# Design and Conservation

Application Number	14/01366/REM
Applicant's Name	Dorchester Group Ltd
Application Type	Reserved Matters to 10/01642/OUT
Location	Former Building 32 and Adj Land at Hayford Park Camp Road
Case Officer	Andrew Lewis

### **Reserved Matters- Application 14/01366/REM - Erection of 74 dwellings with associated car-parking, infrastructure and public open space**

# HEYFORD PARK PHASE D5 a

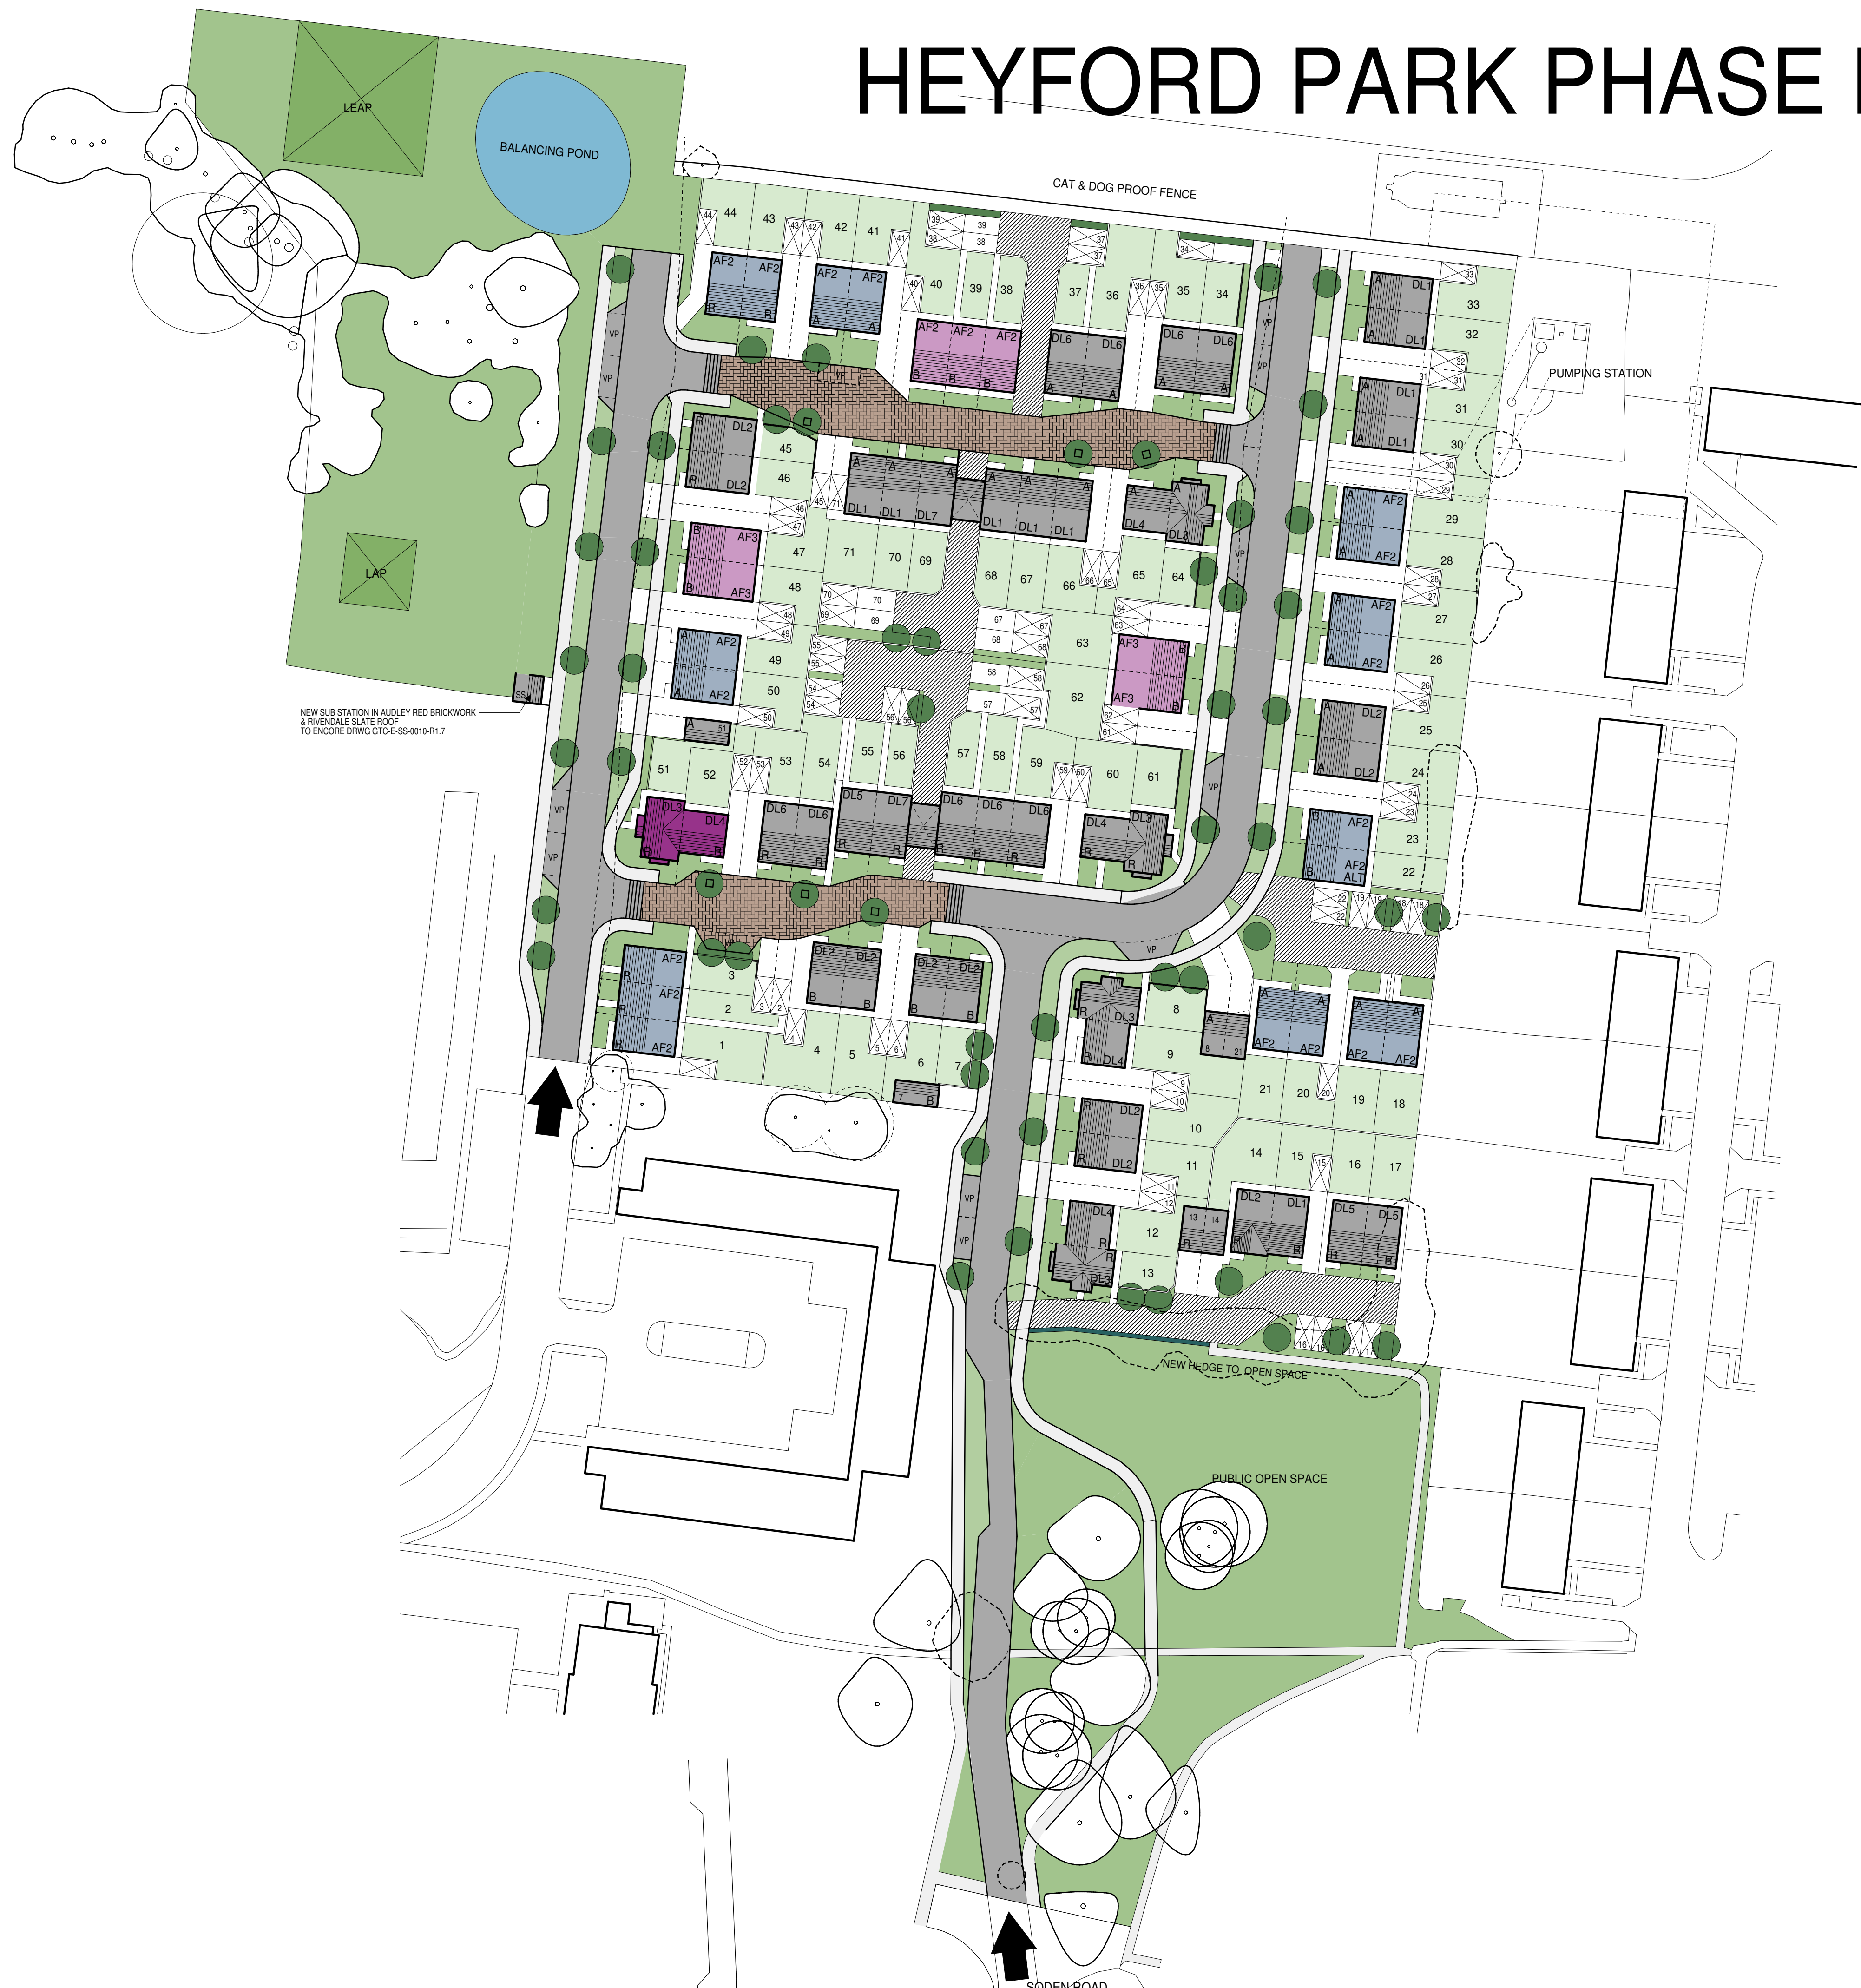
The proposed square has the potential to become a focal point within the scheme and the principle is supported. However, as currently proposed it is a square for vehicles and pedestrians are routed around the edge in a convoluted and unsatisfactory manner. It is recommended that pedestrians become the focus of the square and that the landscape design gives priority to pedestrians in this space. Visitor parking should be removed from the square and provided on-street in parallel parking bays elsewhere.

Recommendation: key corners should be better addressed with buildings that turn-the-corner to avoid blank facades to the street. An additional corner building in rendered finish should occupy plots 2-3 to provide a landmark. Larger detached properties could be used to occupy key sites.

The Code requires that wherever possible windows to habitable rooms should front onto the street and public realm. At ground floor this means lounges or dining rooms. The current proposal shows all lounges located at the rear of the units and kitchens and WC's to the front. There is a need to vary the internal layout of some dwellings to provide natural surveillance from habitable rooms to the street at ground floor and to take advantage of access to sunlight where properties are south-facing. Plots 13-17, 35-46 and 53-63 all have north facing lounges.

Six plots present blank side walls onto the street. The Code requires that there are no blank walls onto the street and public realm. This could be resolved through better use of corner buildings as above.

- The brick dentil course is considered to be an unnecessary detail and could be removed with plain brick or rendered finish extended up to the eaves;
- Where kneeler/corbeling details are proposed they should be of matching brick to the exterior. Pre-cast concrete features should be avoided;

- Window header details should be finished in matching brick to the exterior;
- Ground floor window casements should be of equal or greater size than those at first floor to ensure a proportionate balance on the front facades;
- Door design should be consistent throughout the scheme; and
- WC windows on the front elevations should be removed where possible.

The basic palette of materials is consistent with the Code. However, changes in brick type along street sections should be avoided with groupings of consistent finish preferred.

The Code allows six of the nine parking typologies (Types 2- 4, 6, 8-9) to be used in CA8. Perpendicular parking (Type 4) is permitted where it is separated by landscaping and/or footways into maximum rows of four bays. I would consider this type of parking to be overused on the current proposal resulting in streets and properties unacceptably dominated by parking. I would also consider a number of the plots, particularly the mid-terrace plots, to be too narrow to accommodate two spaces resulting in unacceptable pedestrian access to front doors.

The proposed parking court serves five units at present. The Code allows it to serve up to 8 units. To make best use of the space and infrastructure and to reduce the extent of parking to the front of properties, the courtyard could be expanded to serve additional properties to the north.

Shared and private footpaths to the rear of properties are currently shown as unsecured on the plan. Any path for private/ semi-private use to the side or rear of properties should be secured.

Recommendation: the proposed street design is revised to reflect the street types in the code and to reflect the key movement patterns as identified above. The square should be redesigned to remove visitor parking and prioritise pedestrian movement.

Recommendation: greater variation in the internal layout of some units should ensure that some habitable rooms front the street to provide natural surveillance and benefit from access to sunlight where south-facing. Blank walls to streets should be replaced by corner buildings and building elevations should be enhanced by careful consideration of window placements and consistent and simple detailing.

Recommendation: avoid interchanging brick type between dwellings and group together to ensure consistent street fronts.

Recommendation: that the prevalence of perpendicular parking to the front of units is significantly reduced by either a reduction in the number of spaces provided (Code allows for 1 space per two-bed unit) and/or a reduction in the number of properties. On-plot parking to the side of units and/or on-street parking is preferred allowing for clear defined boundaries between plots. Footpaths to front doors should be direct and uninhibited and footpaths to the rear of properties should be secured. Better use could be made of the proposed parking court.
